Your Ref: OWQC22431
Our Ref: EP/36/19/HH
Please ask for:
Mr A Wood

1st May 2019

Change of pitched roofs to full gable roofs, new mono-pitch dormers to front & rear elevations on main dwelling, new gate, posts & fence to front of property site & change of existing annexe roof to split mono-pitch roof.

9 Myrtle Grove East Preston

Drawing: 311 – Proposed Elev.'s N & W

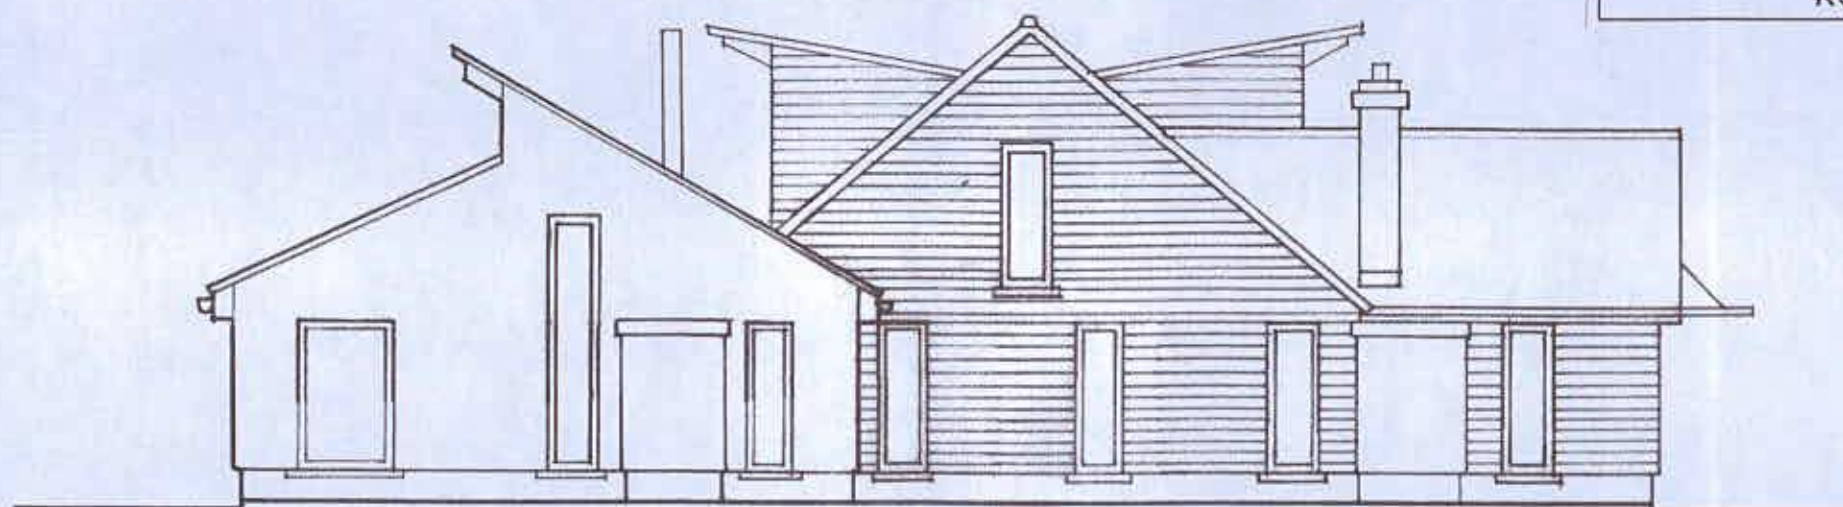
The committee agreed the proposed design was unsympathetic and would have an unacceptable impact upon the character of the immediate locality, contrary to the Arun Local Plan and the East Preston Neighbourhood Plan. The proposed dormers are not subservient to the existing roofline, contrary to the East Preston Neighbourhood Plan.

The committee agreed the choice of colours is out-of-keeping with the existing streetscene. (Almost) all other properties in Myrtle Grove use a clay palette for their roofing materials. This is contrary to Policy 1 of the East Preston Neighbourhood Plan, s4.12 of which states, the materials used in new or altered buildings should harmonise in both colour and texture with the materials used in adjoining buildings.
